Our ref: HA/2019/121832/01-L01
Your ref: LU/354/19/DOC
Date: 19 December 2019

Approval of details reserved by condition imposed under ref LU/330/18/PL relating to condition nos 9 - periodic verification reports

Land South of Cornfield Close, Littlehampton, BN17 6LD

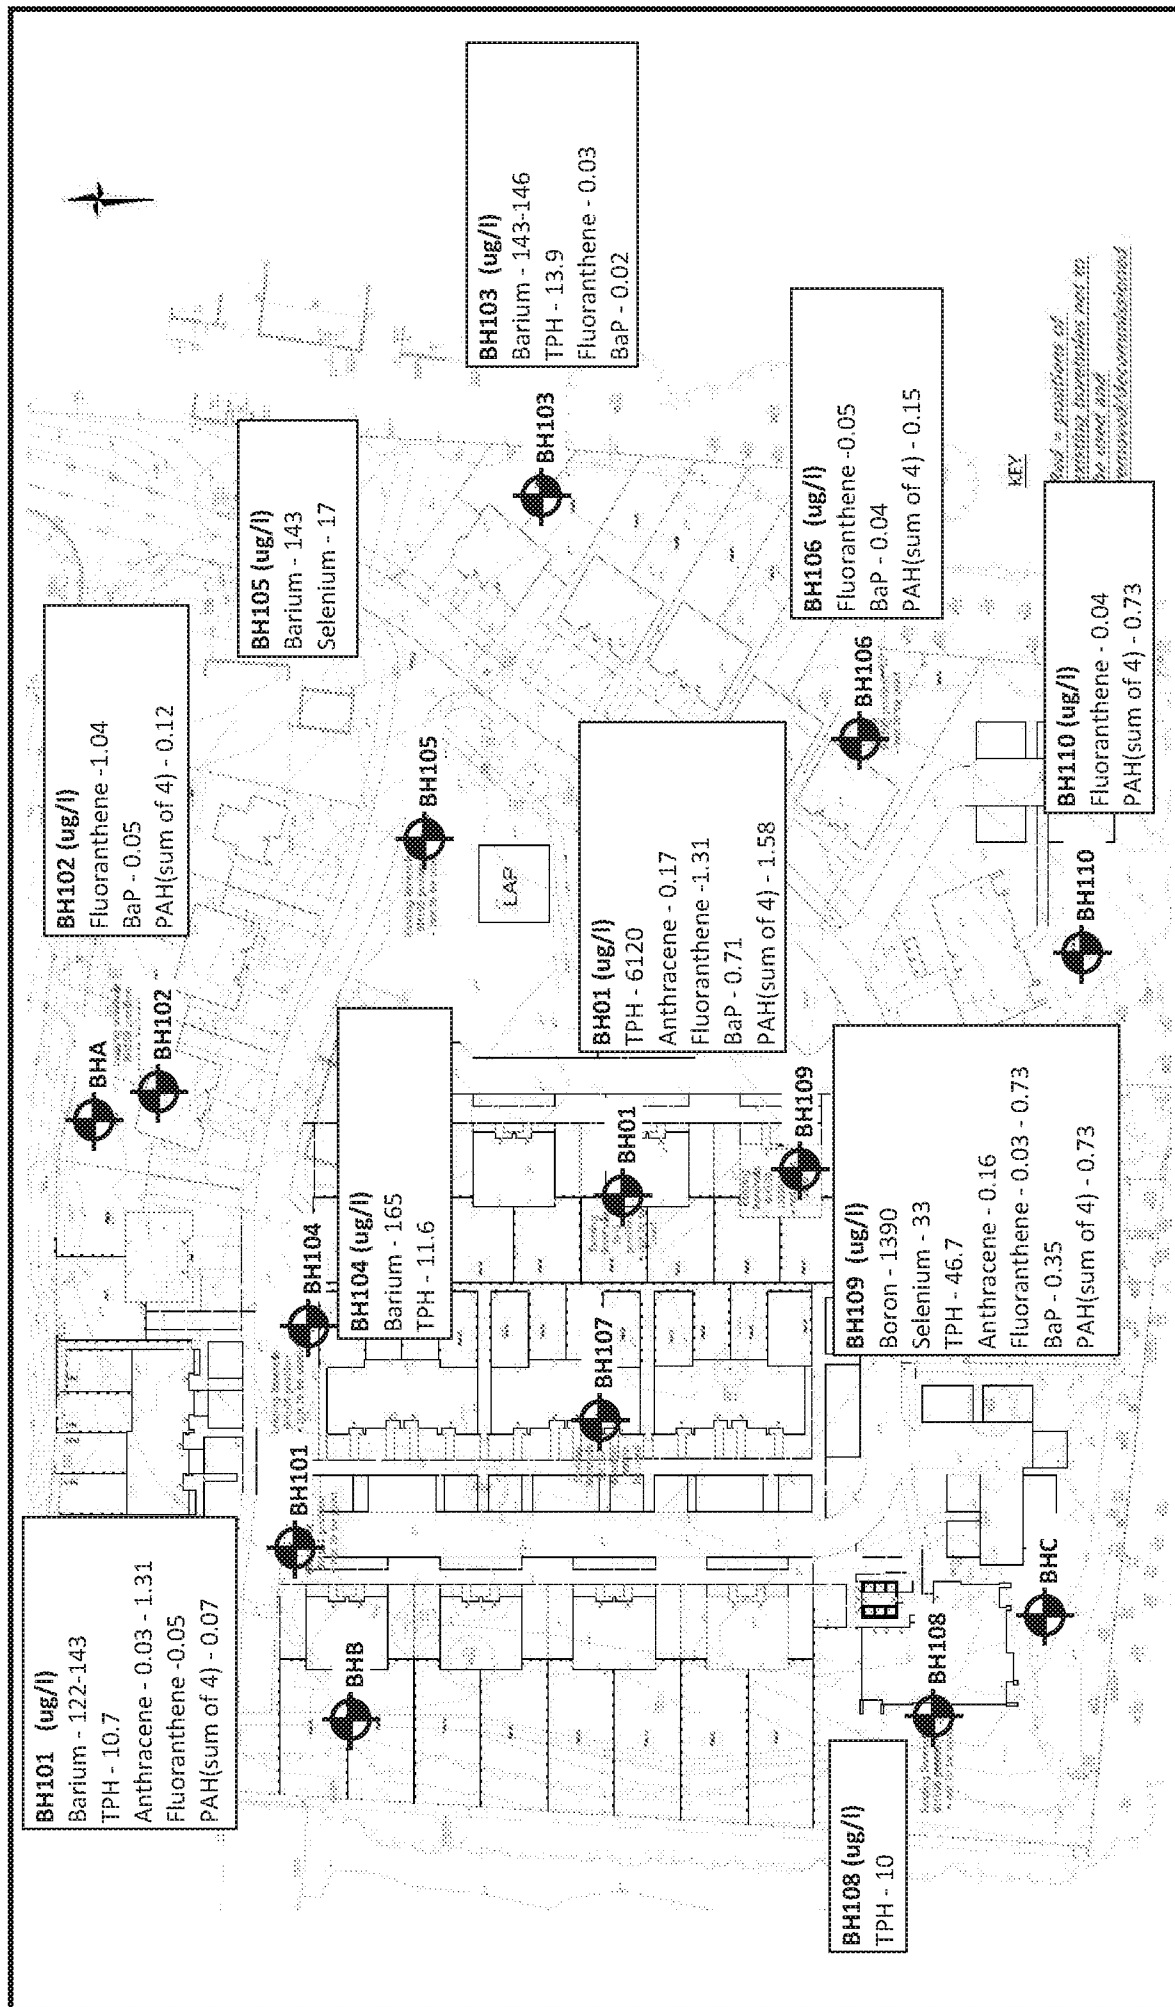
However, we would invite comment from the applicant regarding the groundwater quality data submitted in document 2. We note BH01 & BH109 have significant exceedances for hydrocarbons. Does the applicant believe that these readings emanate from a pinpoint source within the made ground and if so, is this area of made ground scheduled to be removed?
